Our Ref: BTC00
Your Ref:
Date: 12th February 2021

**DEADLINE 3 – APPLICATION BY HIGHWAYS ENGLAND FOR A DCO FOR THE A1 IN
NORTHUMBERLAND – MORPETH – ELLINGHAM
COMMENTS ON RESPONSES SUBMITTED FOR DEADLINE 2**

6.6 Environmental Statement – Figure 7.11 Vegetation Clearance Plans

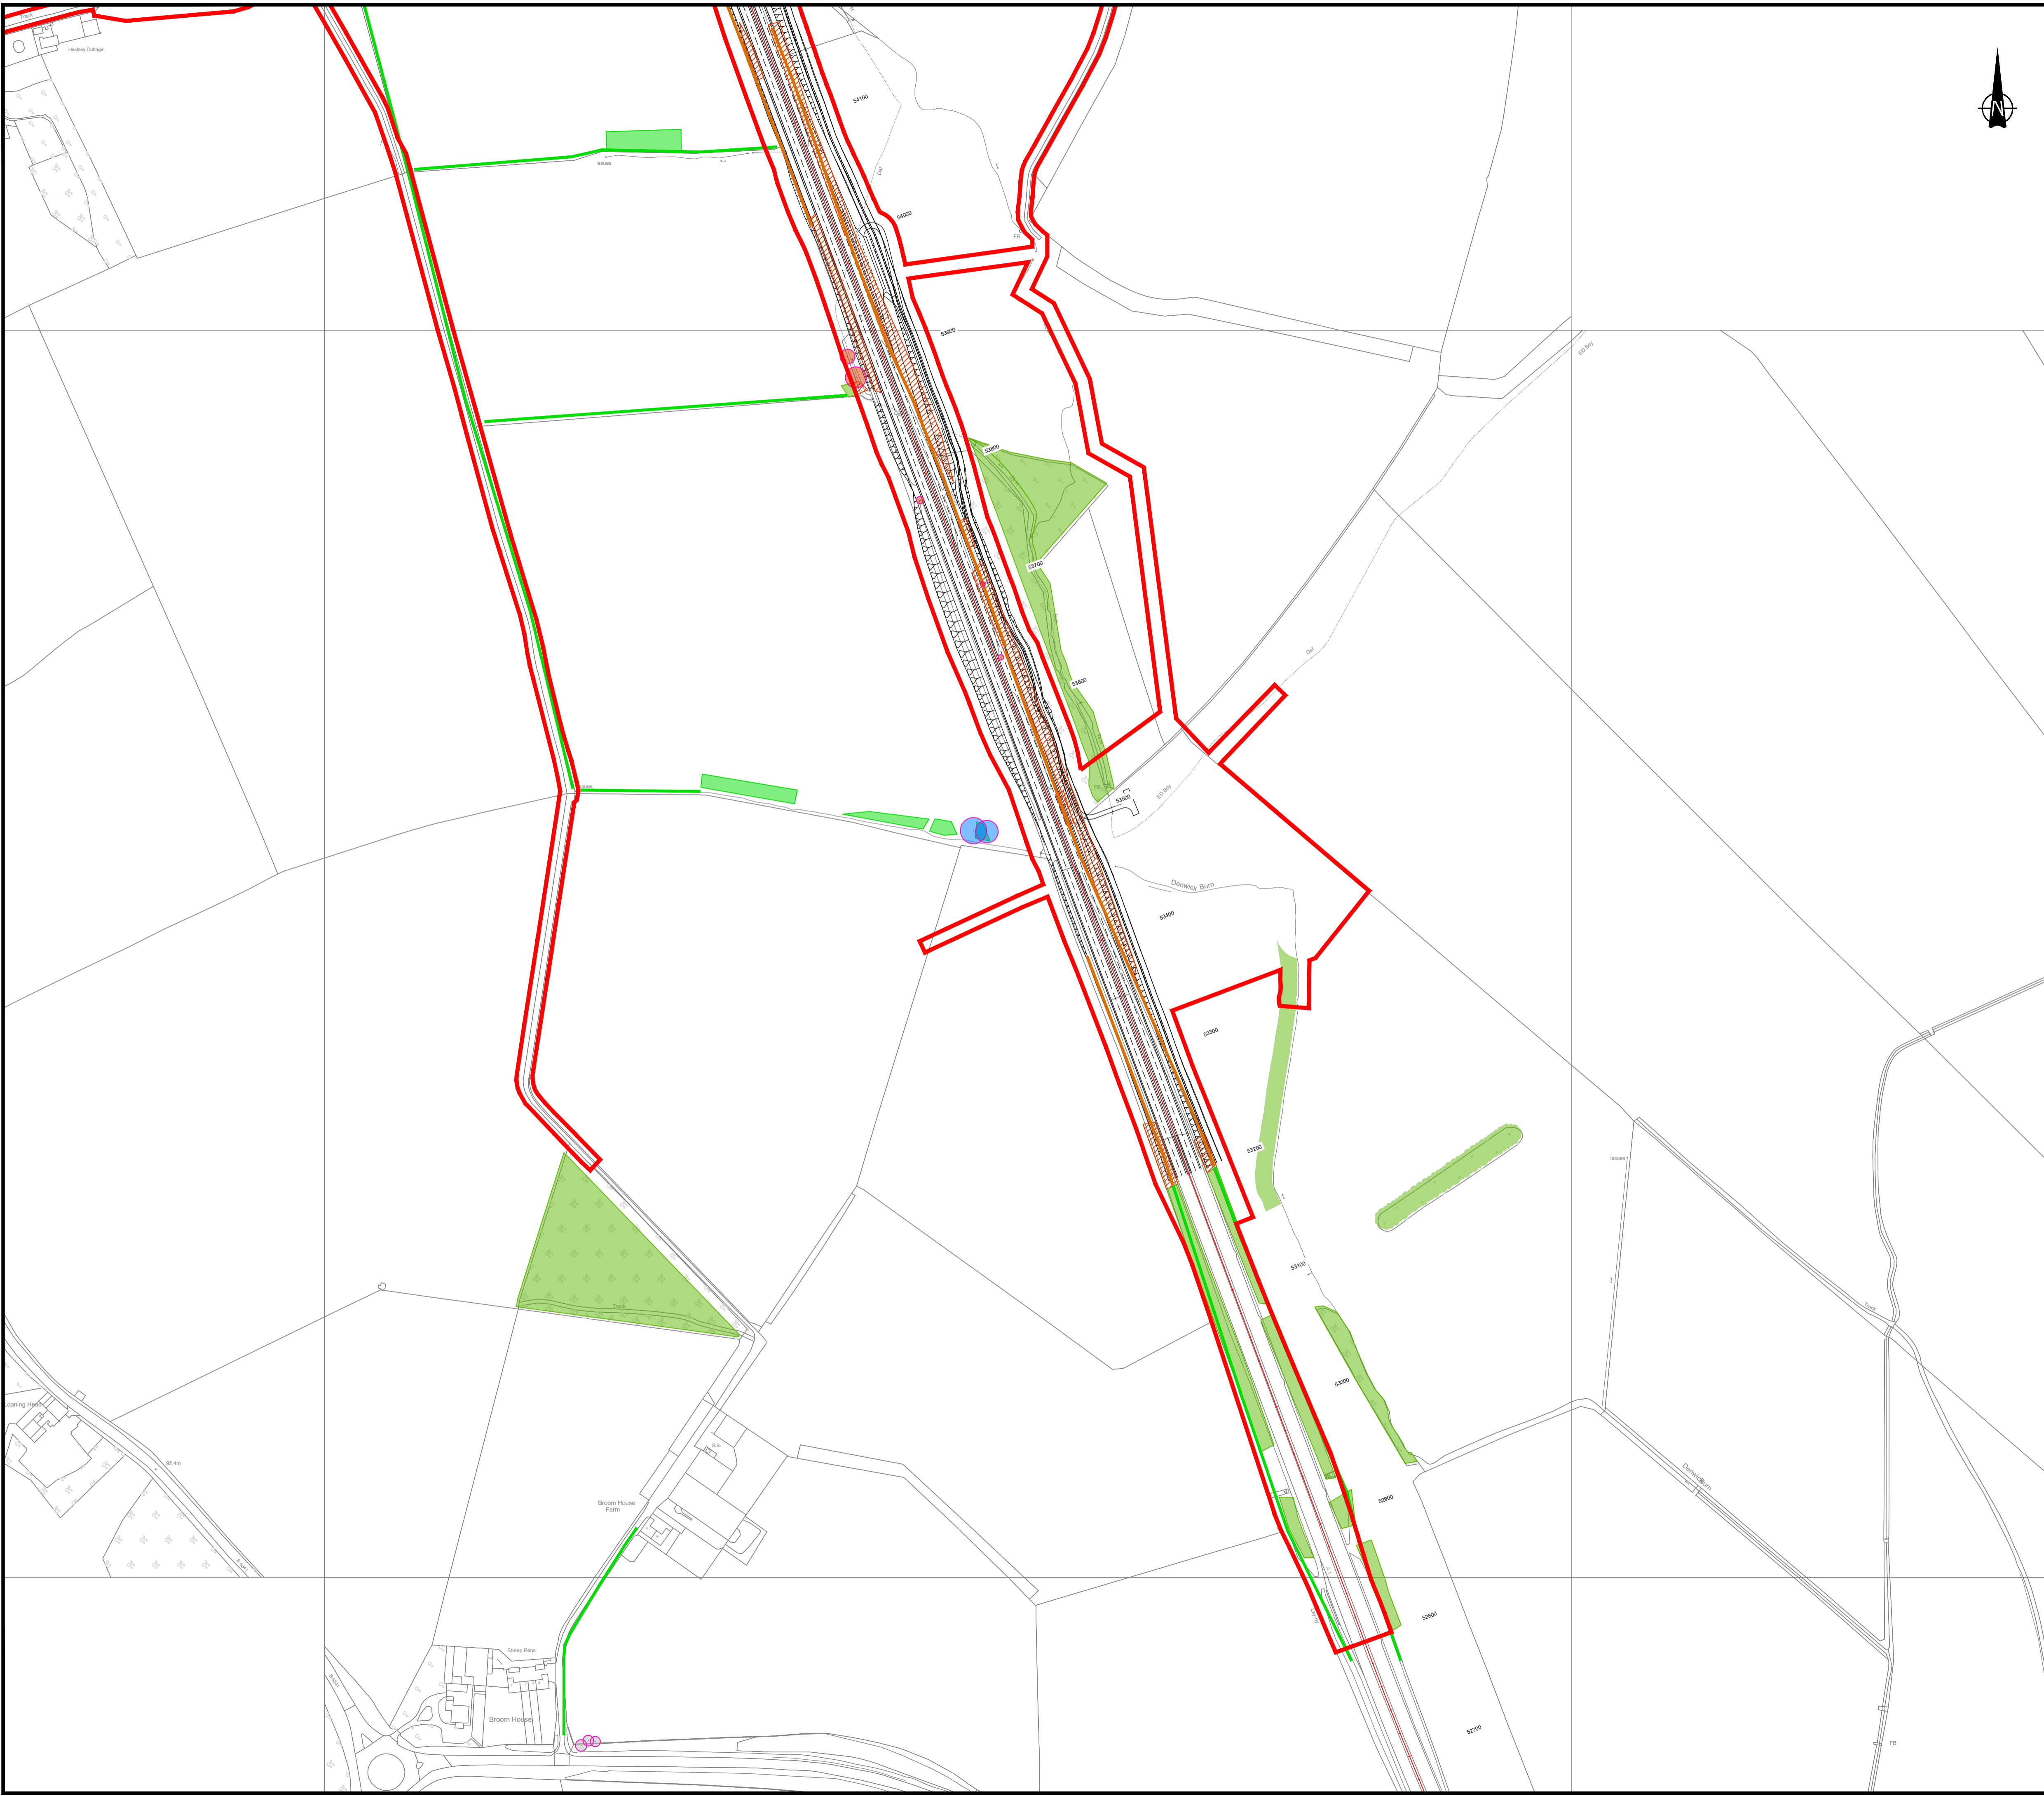
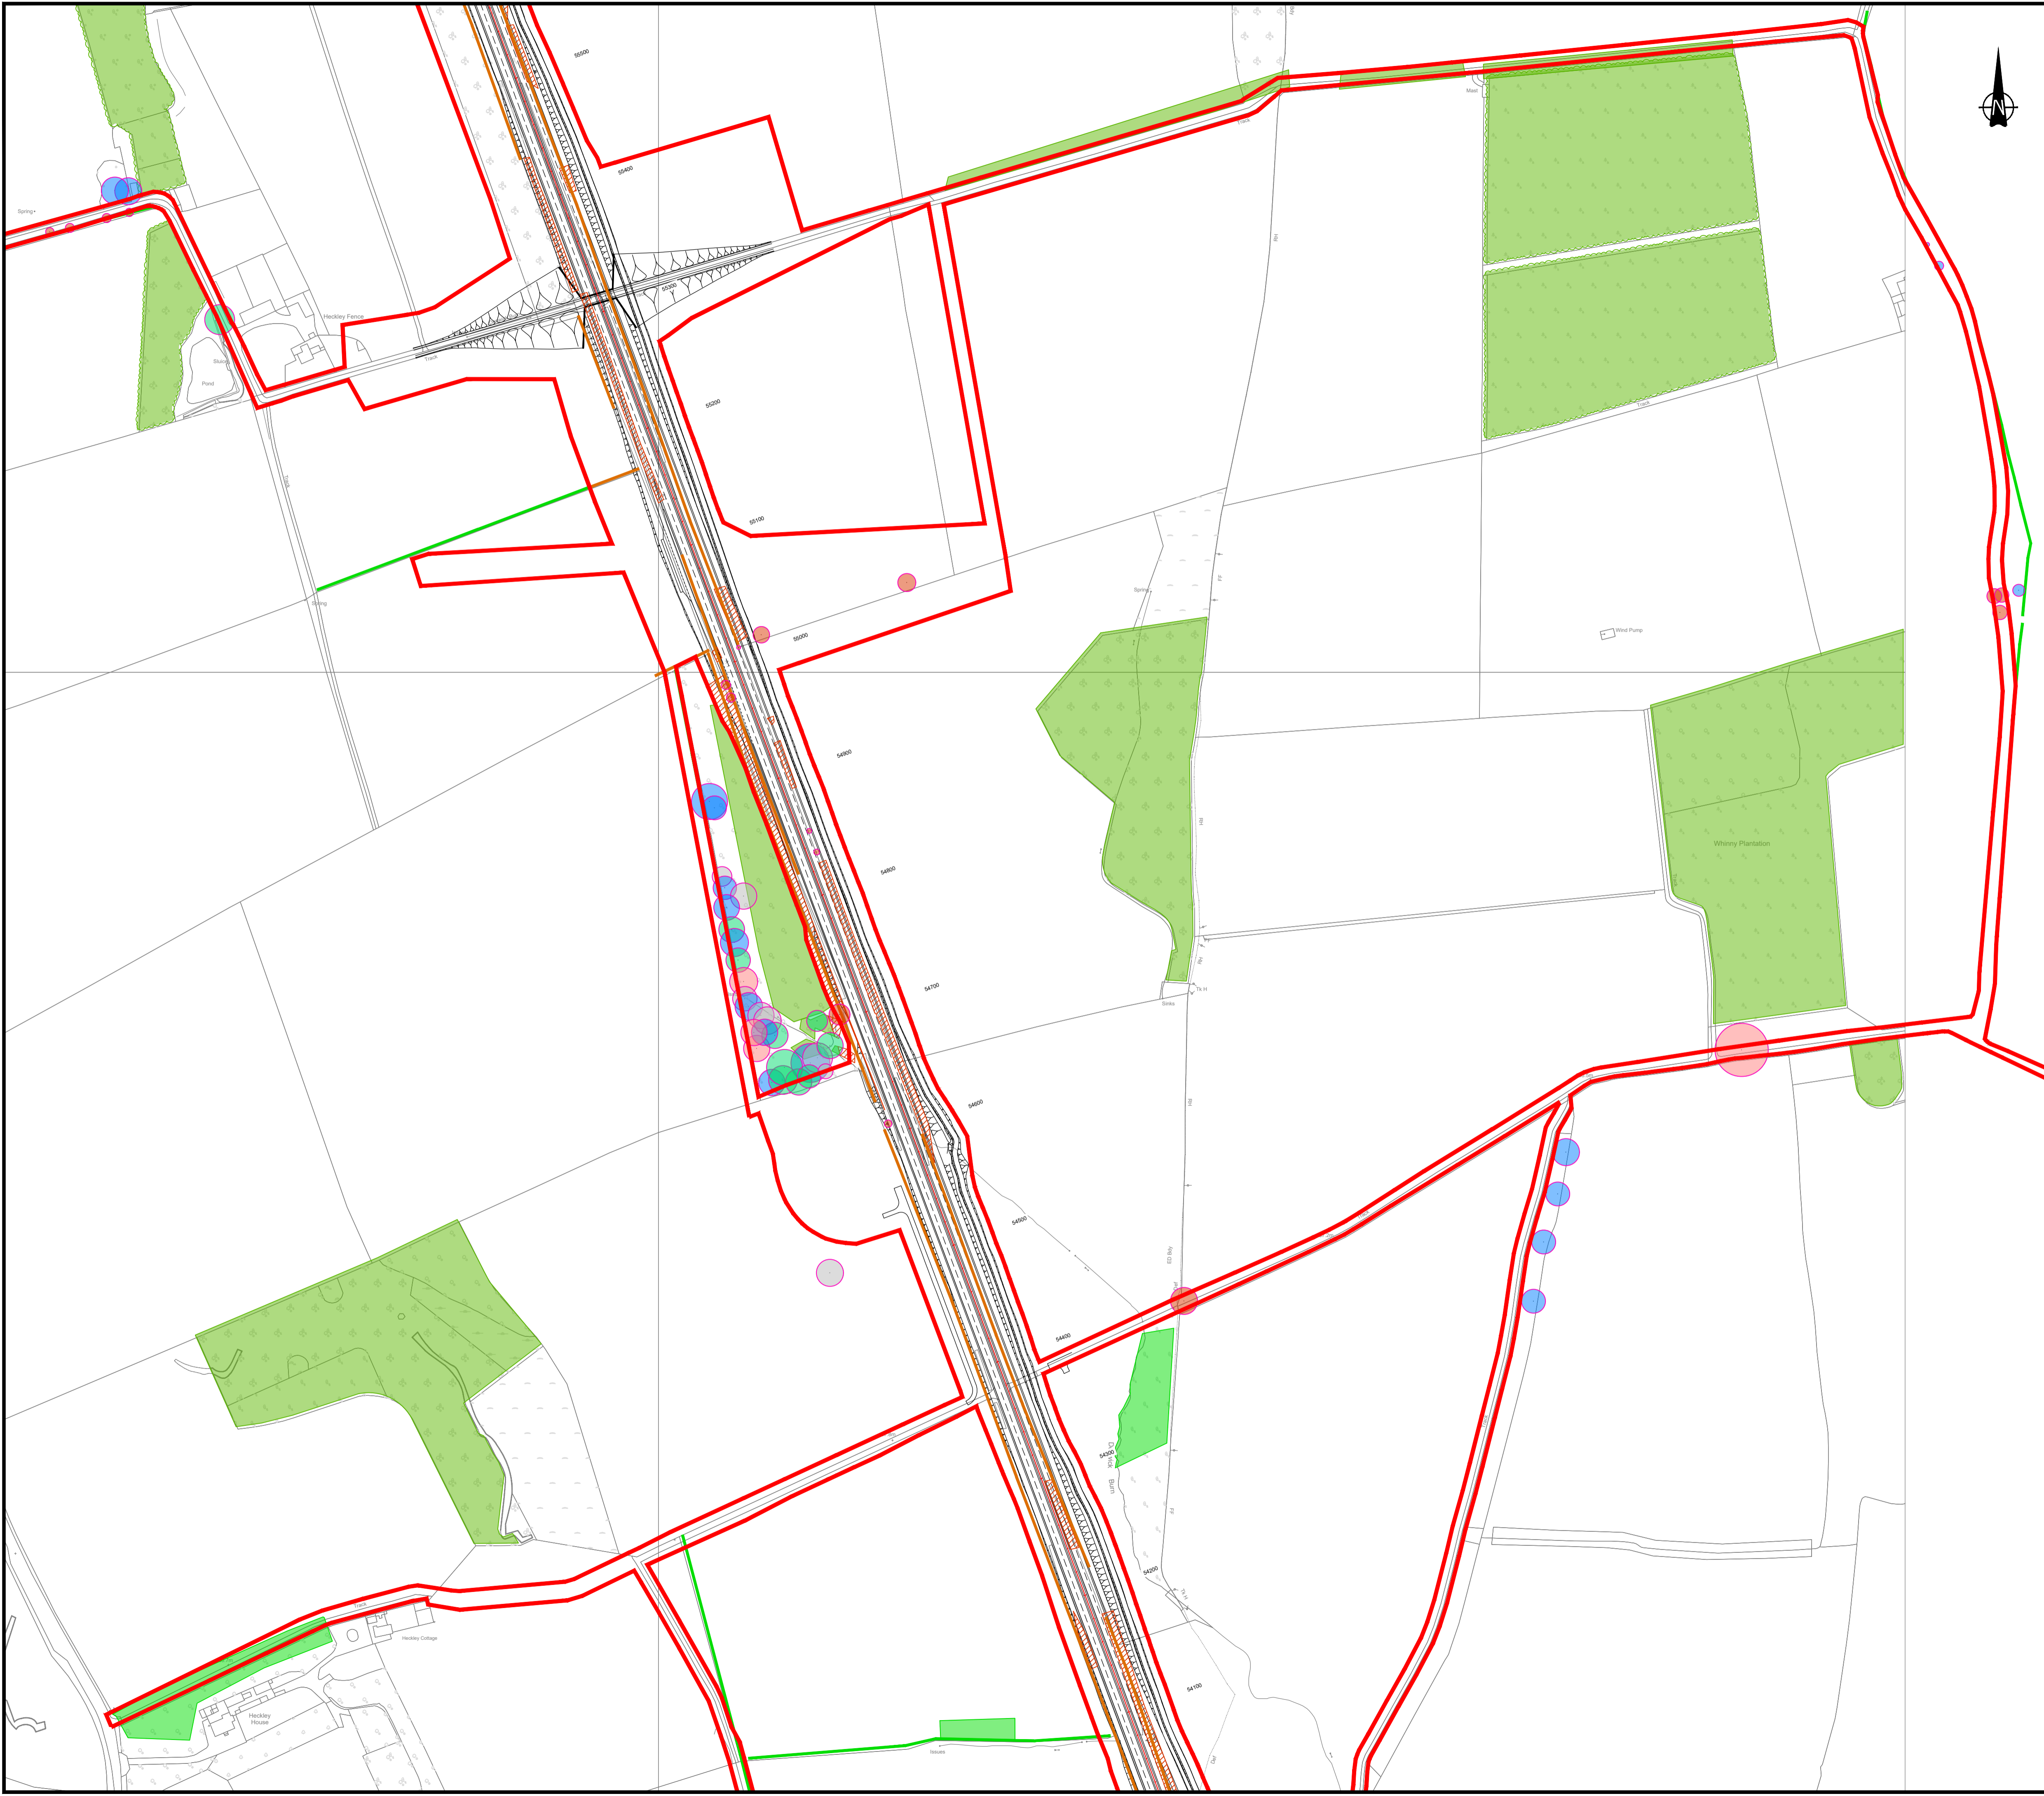
1. Vegetation Clearance –we note submission of Document TR010059 – 001182 6.6 ED Part B Figure 7.11. The document states that vegetation in front of West Linkhall Farm and West Lodge at Charlton Hall is to be removed. We have had verbal confirmation that this is not the case and that whilst some maybe removed, not all of it will be. We are concerned that the DCO is assuming the full removal and we would contest that this is not necessary following conversations with HE and their representatives.
